Re: Twilight Homes at Montage 6 at 2200 O’Keefe Ave. SE
Block 1 : Lots 1 – 13
Block 2: Lots 1 - 26
Block 3: Lots 1-26
Block 4: Lots 1-23
Erosion and Sediment Control Plan
Engineer’s Stamp Date 5/28/25 (R16E003C)

Based on the information in your submittal received on 5/28/25, the ESC Plan is acceptable for inclusion in the SWPPP with the following conditions. Additionally, the EPA Notice of Intent (NOI) has been reviewed and signed by the city, and it is attached. Therefore, this project is approved for Building Permit (BP) provided that the following corrections are made to the ESC Plan and emailed to the SWQ section before commencing BP construction and before placing it in the SWPPP.

Page 1: ESC Plan Standard Notes and Pond Stabilization Specifications

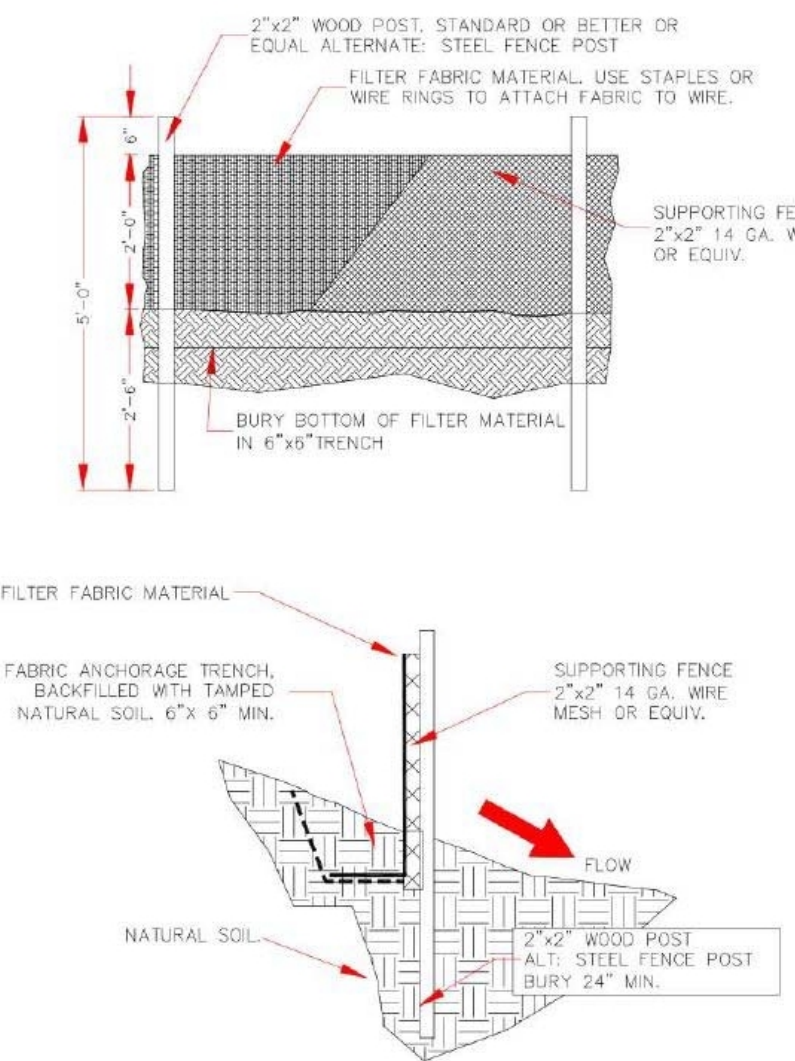
1. The ESC Plan Standard notes on sheet 1 are outdated and must be updated to the attached version.
2. The City of Albuquerque has a long-standing policy of allowing sediment in new subdivision streets until the first house in the subdivision is occupied. Thereafter, sediment isn’t allowed in the streets, and controls are required on all of the bare dirt lots that don’t satisfy the Final Stabilization Criteria of CGP 2.2.14.c. However, a note on sheets 2 and 4 states, “BMPs shall be installed at the individual lots as building commences,” implying that the controls will only be installed on lots where building permit construction has commenced. To clarify, please change the note to say “These controls must be installed on all of the lots by the time the first house in the subdivision is occupied.

Page 2: Erosion and Sediment Control Plan

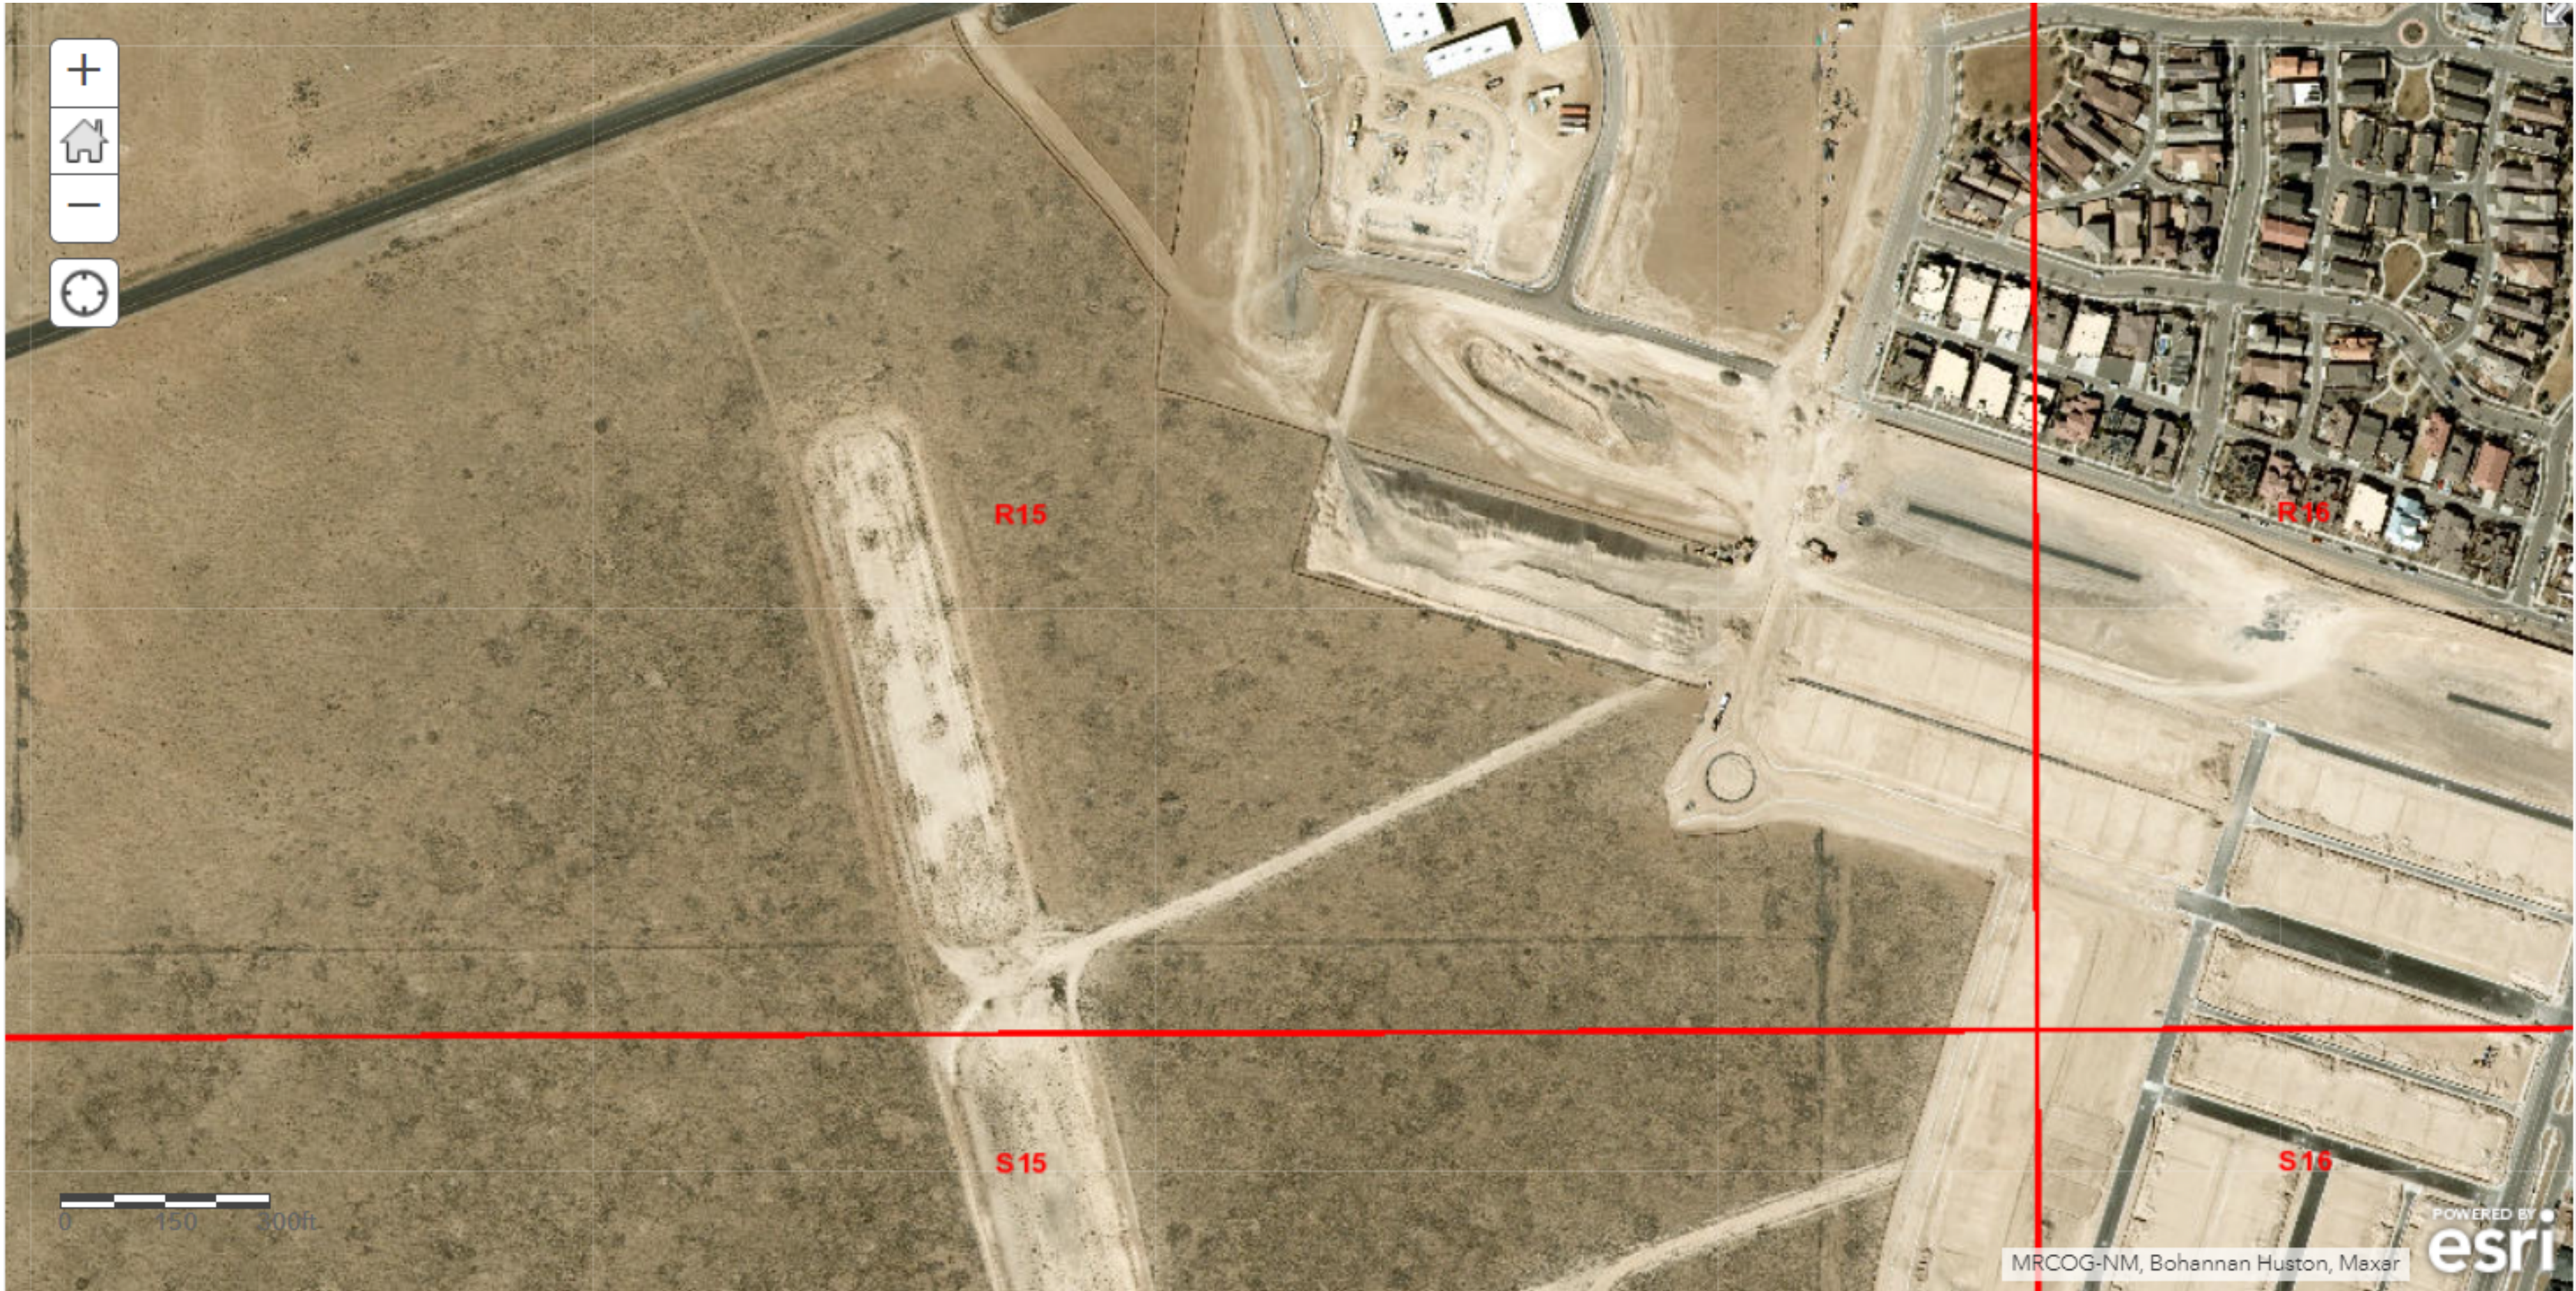
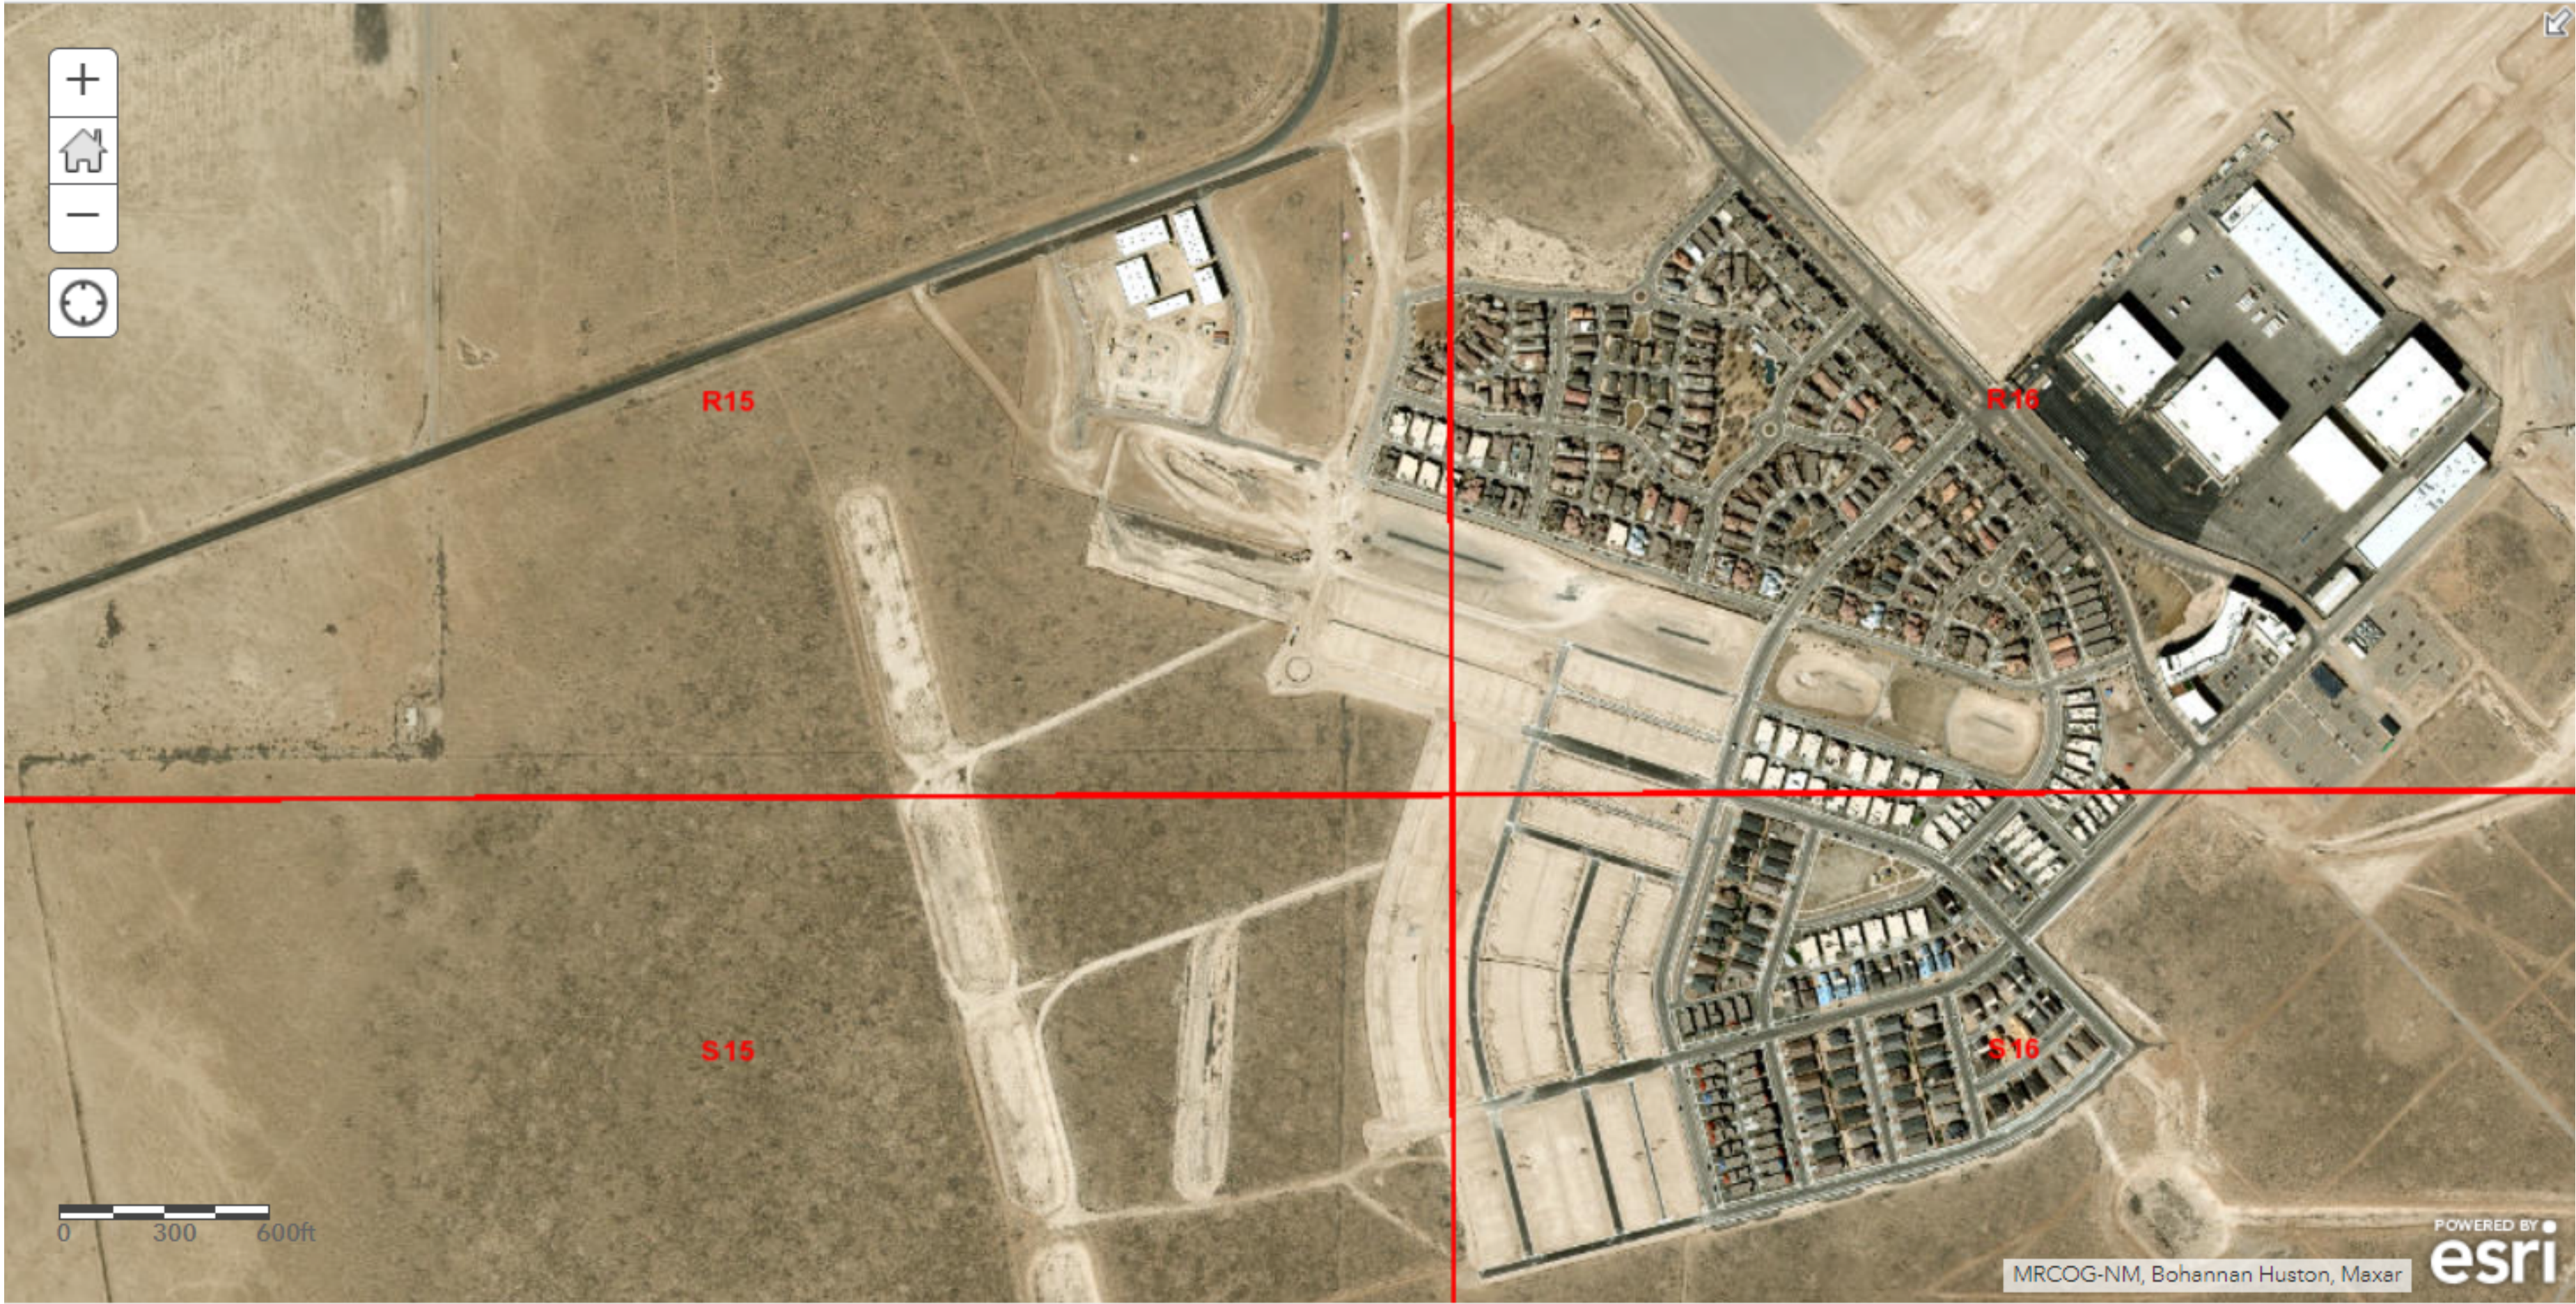
3. The stabilization requirements of CGP 2.2.14 are not included in the ESC Plan. Notes must be added to the ESC Plan stating how this site will comply with the CGP.
